SSD 7047 – Darling Harbour Integrated Display System – Response to Submissions

Government Submissions	Response
<i>Department of Planning and Environment</i>	
Third Party Advertising Further details are required for the proposed third party advertising, and in particular for 'partner info' and 'precinct partner' advertising including: ▪ mechanisms to control advertising content; and ▪ frequency and duration of third party advertising in comparison to other displays associated with signage including way finding and advertisement of events associated with the site.	In assessing this application, a certain level of planning ambiguity is caused by the requirement to define the intended use of the development through SEPP 64. In our view the Digital Content Management Plan (DCMP) (as updated) can help to address this ambiguity. Elements of the proposed development will be used for a range of uses, including: ▪ Precinct information; ▪ Wayfinding and public transit information; ▪ Promotion of public and cultural events; ▪ Health and safety information; ▪ Emergency communication; ▪ Public art; and ▪ Third party advertising Access to the proposed IDS will only be available to corporate part

6 DIGITAL SIGN T17 WEST ELEVATION

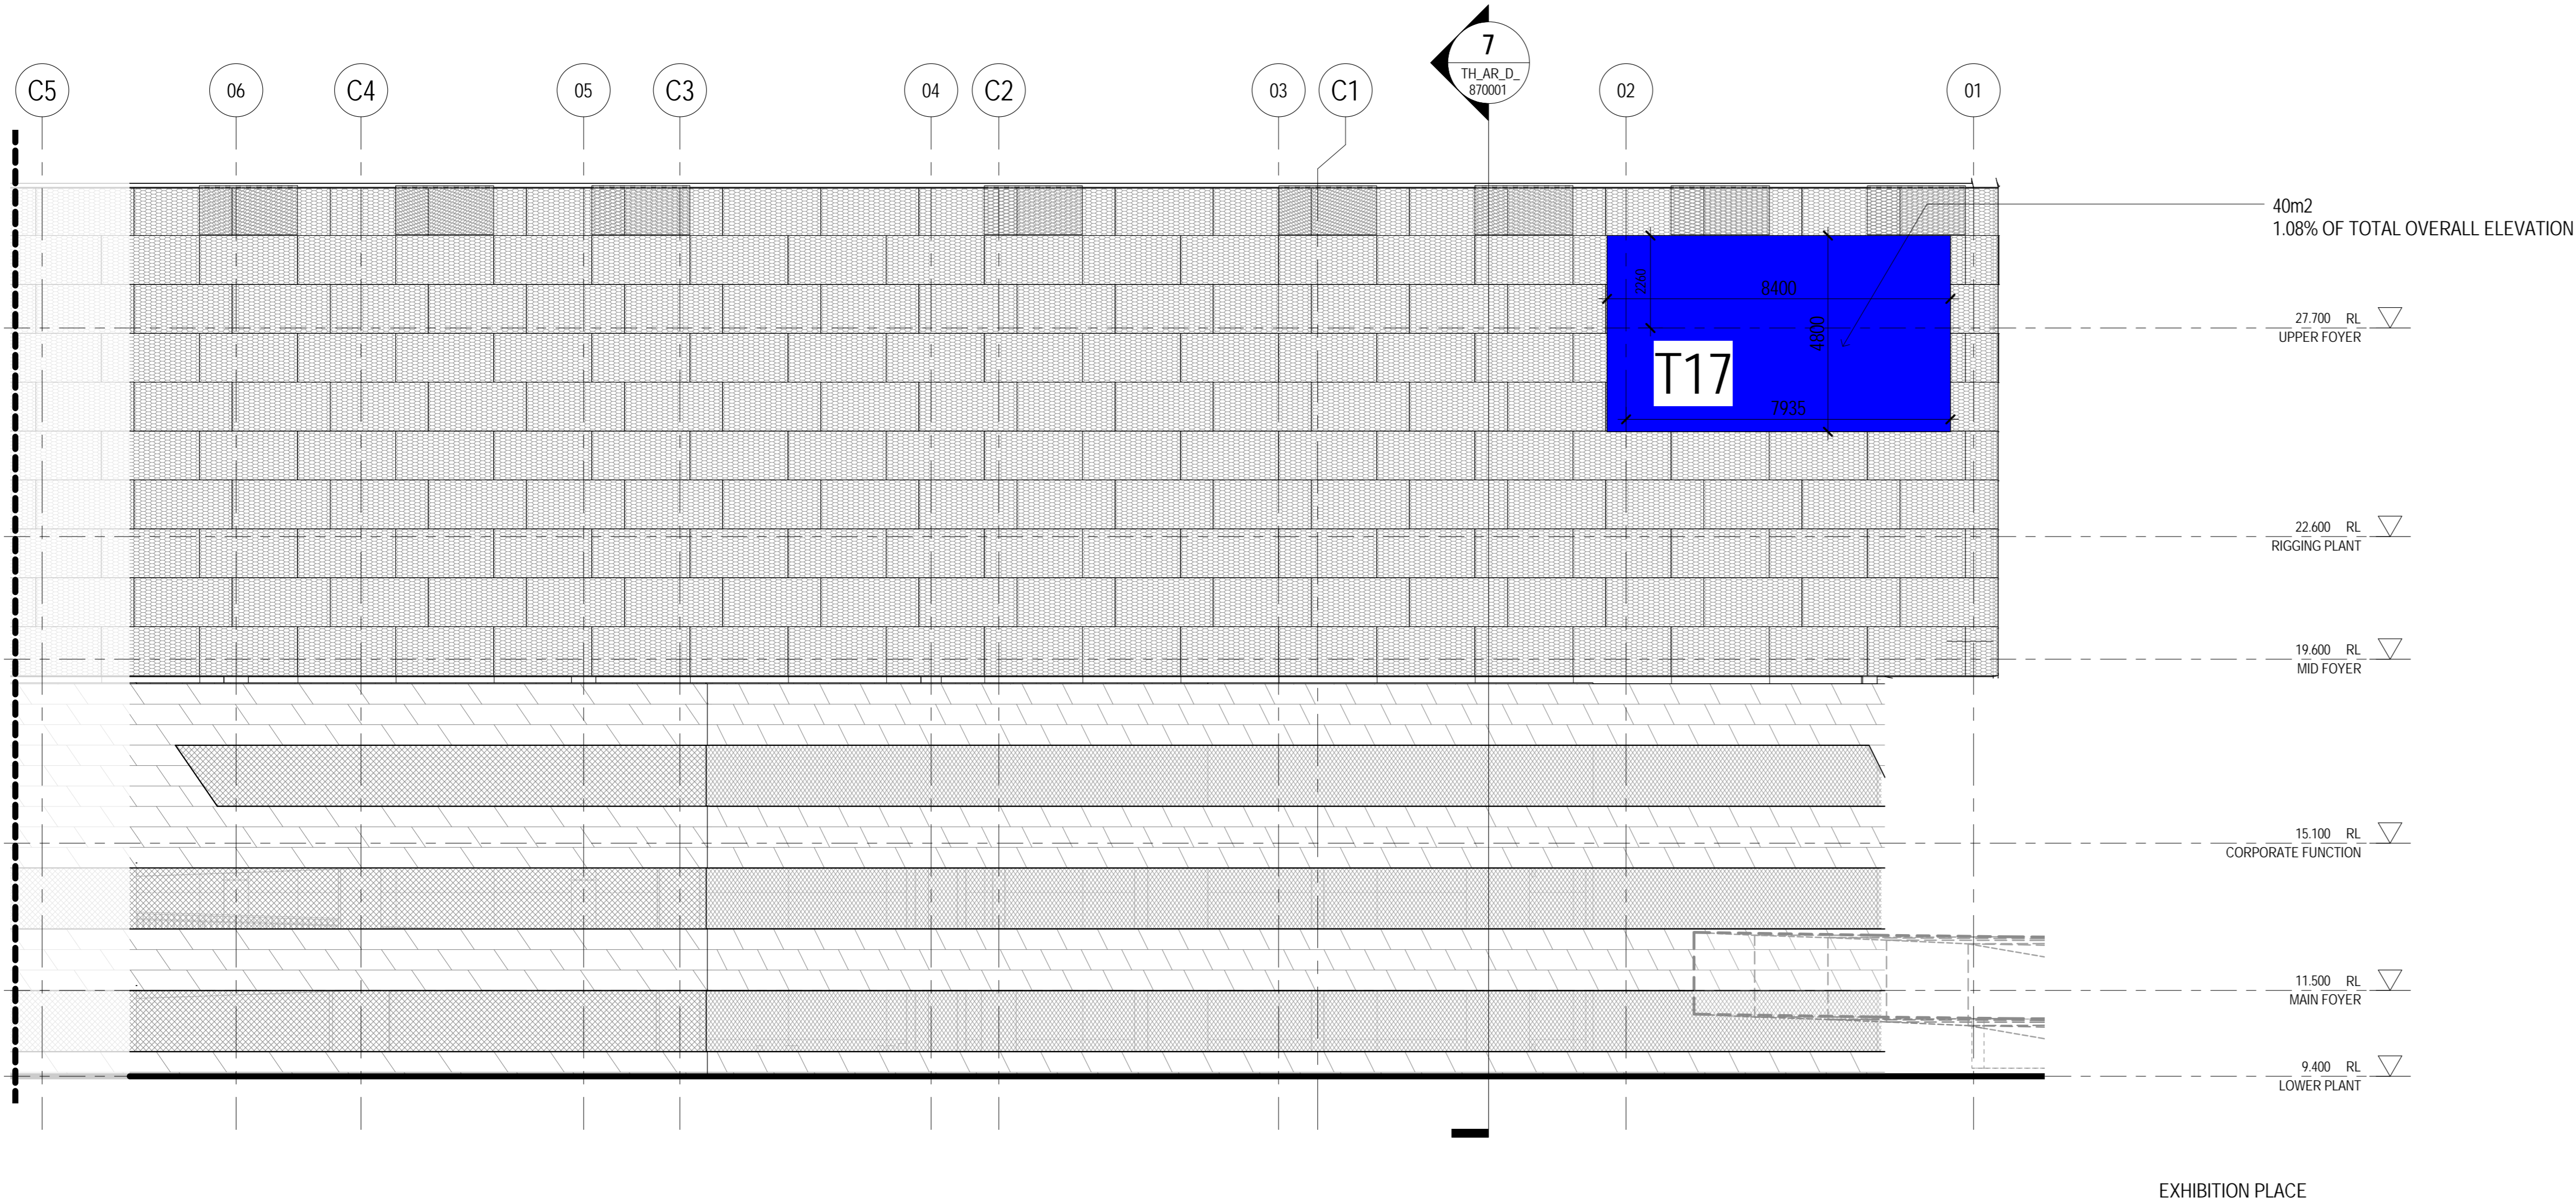
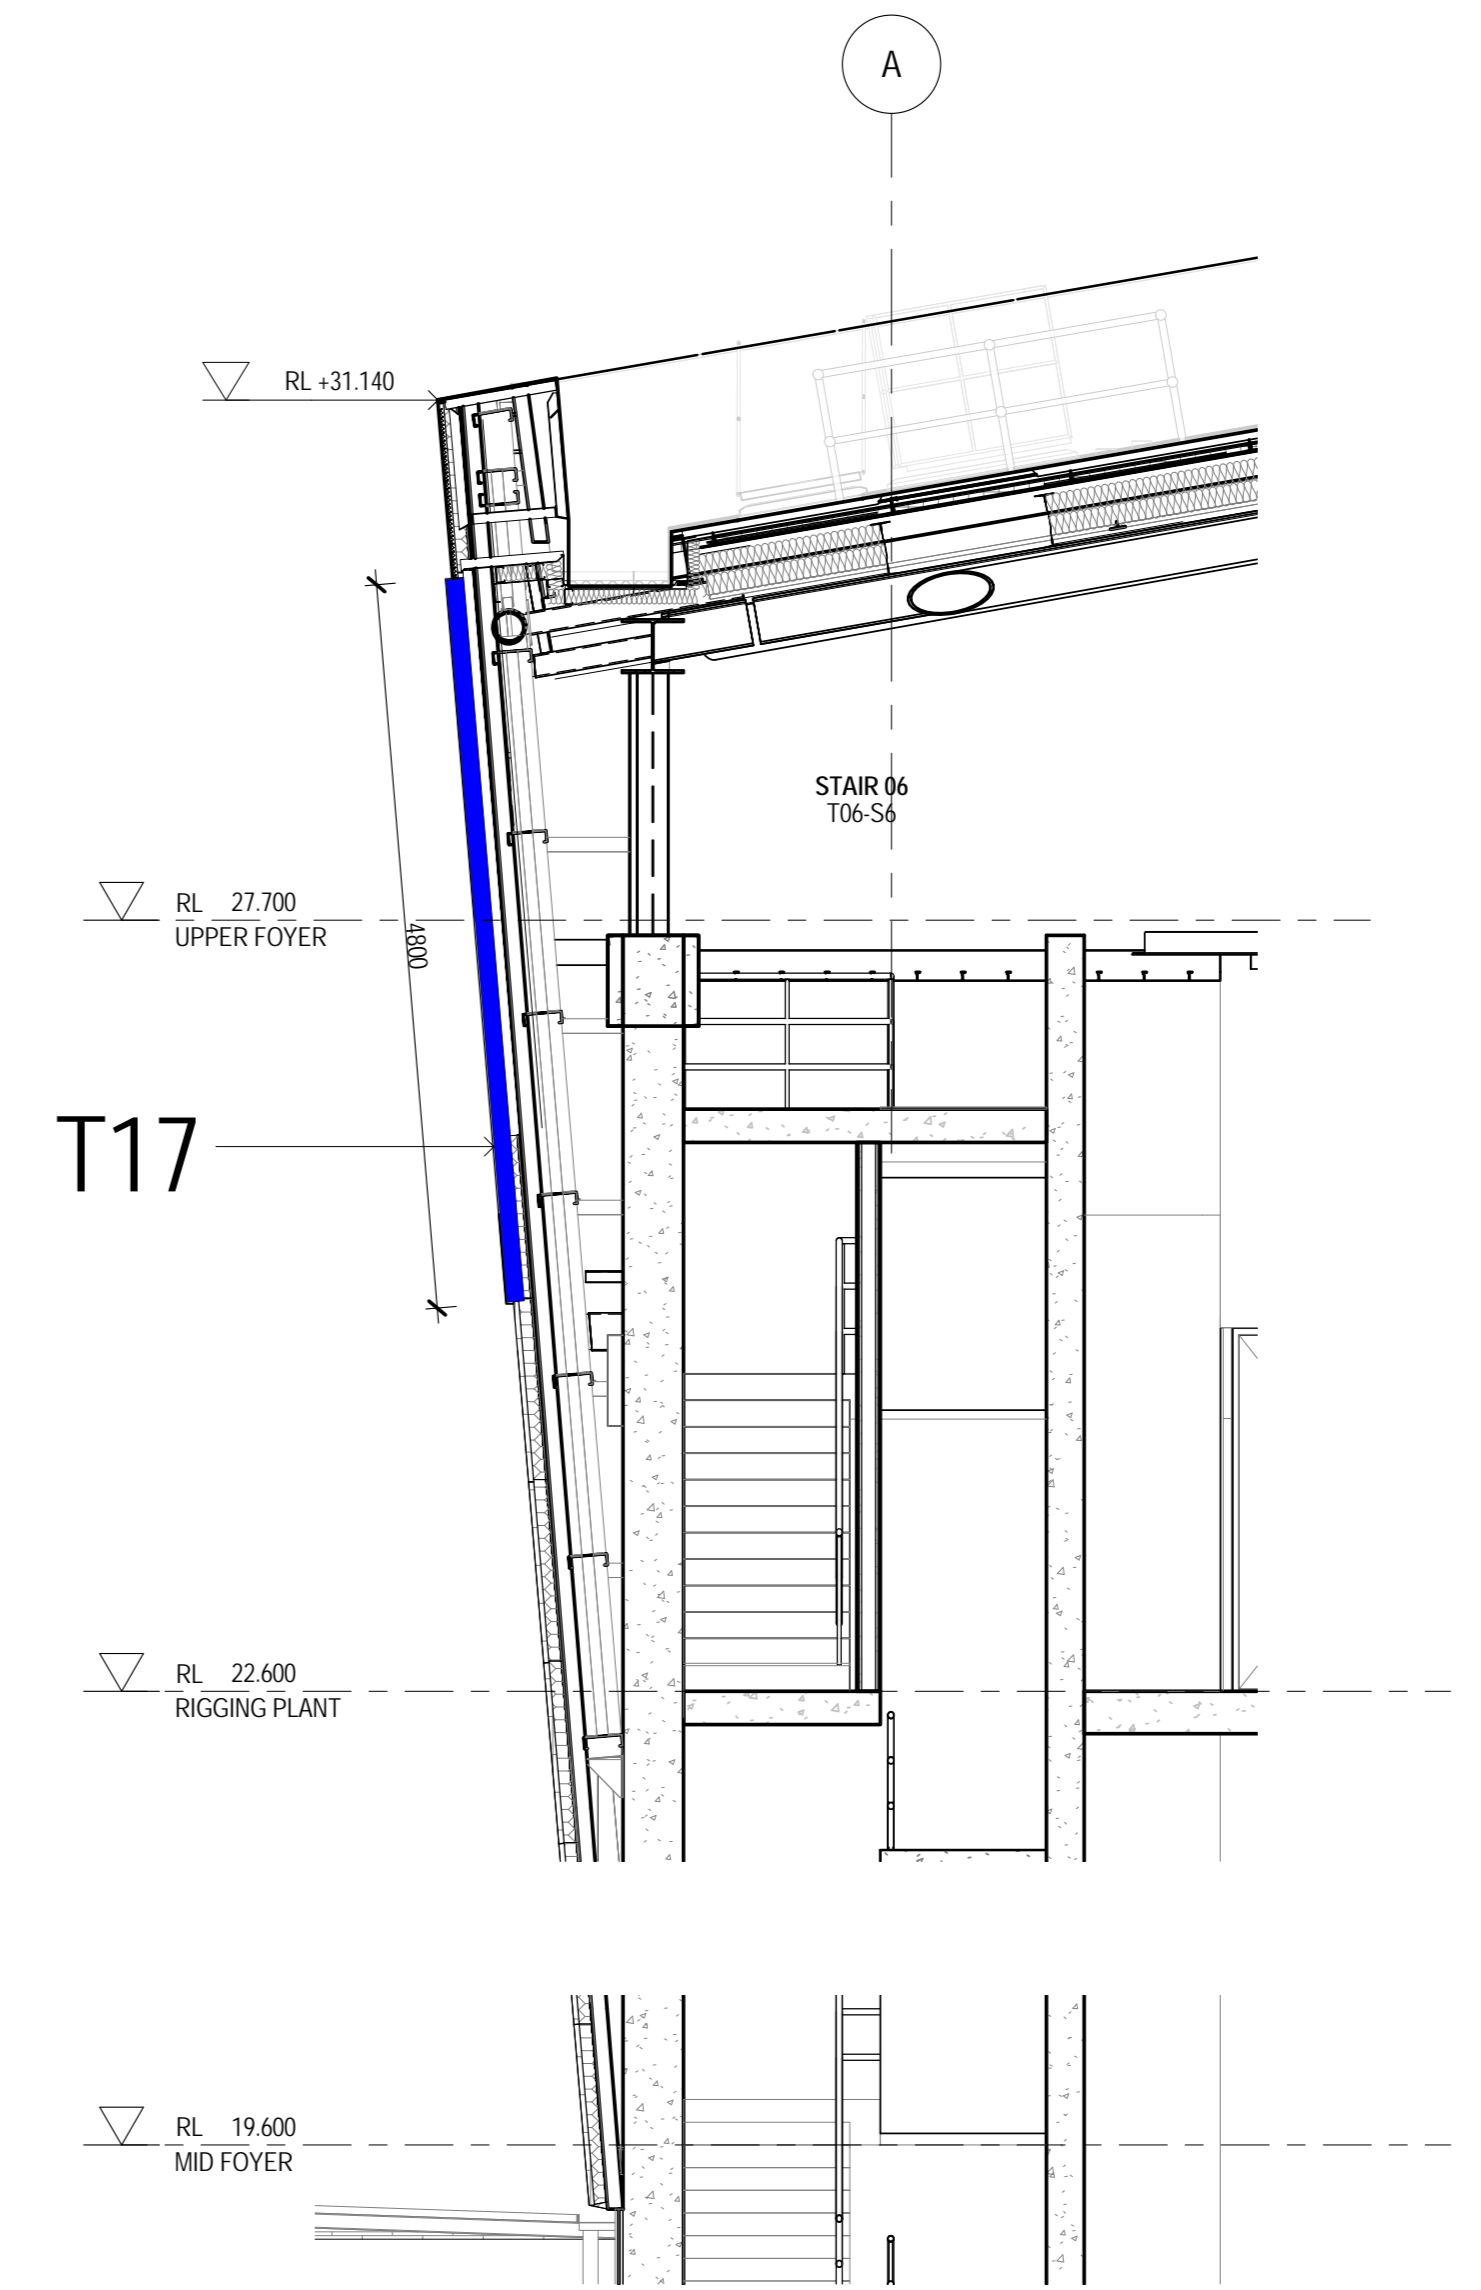
Government Submissions	Response
	area of any one sign. This overlap is illustrated in Appendix G . Also shown in Appendix G is the likely cumulative audibility zone, when the impact of each one of the IDS elements is considered.
Digital Billboard Advertising Sign (T-17) T17 is prohibited as it is greater than 45m ² and a Development Control Plan has not been prepared in accordance with SEPP 64. The sign should be amended to comply with SEPP 64.	The size of Sign T-17 has been reduced to 40m² and as such is not affected by Clause 19 of SEPP 64. Modified architectural drawings have been prepared and are provided as Appendix C. A thorough assessment of the impact of T-17 was included within the EIS as exhibited. As the display area of T-17 has been reduced by over 50%, the anticipated impact is also greatly reduced. No further assessment of impact of the modified T-17 is considered to be required.

A cumulative road safety assessment is required for Sign T17 noting that an electronic advertisement has also been approved also facing Pier Street for the North West plot.	An additional cumulative assessment has been undertaken by ARRB and is provided as Appendix F .
Consideration should be given to increasing dwell times of electronic display signage having regard to Council's comments.	Noted. The proposed dwell times within the Digital Content Management Plan (DCMP) have been updated to address Council comments. A revised DCMP is provided as Appendix D .
Illumination Further consideration should be given to reducing the illumination of all signs during night time hours in accordance with Council comments, to reduce potential impacts to the amenity of nearby existing and future residents.	Council has suggested that the illuminance of the proposed development be reduced to 2 lux. The lighting assessment that was undertaken as part of the EIS and submitted as Appendix E noted that: <i>Within a commercial built environment, AS/NZS4282 recommends that during pre-curfew hours a maximum illuminance level of 25 lux is permitted in the vertical plane at the boundaries of nearby residential properties. Within curfew hours this level is reduced to 4 lux.</i> Council is therefore suggesting a reduction of 50% of the luminance permitted during curfew hours beyond the recommendation within the Australian Standard. Arup's lighting assessment that was submitted with the EIS as Appendix E notes that the following elements of the IDS could exceed 2 lux when viewed from 100m during curfew hours, these are: ▪ E-02 (2.08 lux); and ▪ T -17 (2.03 lux). It is noted that the area of T-17 will be reduced by approximately 50% from that assessed and therefore the illuminance impact of this sign will also be commensurately reduced by approximately 50%. The remaining element of the IDS that would result in an illuminance of greater than 2 lux at 100m is E-02. The nearest residential receiver to E-02 are located over 250m from the source and at this distance the illuminance of this sign has been assessed as being below 0.5 lux. As a result we have no objection to a requirement to comply with a maximum illuminance of 2 lux during curfew hours.

Sign T-17 T-17 is a 84m² digital LED screen that is located on the western face of the Theatre that will be used to advertise current and upcoming events at the Theatre, and for third party 'precinct partner' advertising.	The size of Sign T-17 has been reduced to 40m² and as such is no longer affected by Clause 19 of SEPP 64. Modified architectural drawings have been prepared and are provided as Appendix C. A thorough assessment of the impact of T-17 was included within the EIS as exhibited. As the display area of T-17 has been reduced by over 50%, the anticipated impact is also greatly reduced. No further assessment of impact of the modified T-17 is considered to be required.
T01, T11A, T11B, and T12 The City objects to these signs being used for third party advertising, as is currently proposed.	The City's comment is noted. It is reiterated that access to these signs will be provided to the State's corporate partners as a minor component of the total content provision across the IDS and that this content will be provided in line with the provisions of the DCMP. Although this access to the IDS for the State's corporate partners is defined under SEPP 64 as <i>Third Party Advertising</i> the content of the signs will be strictly controlled.
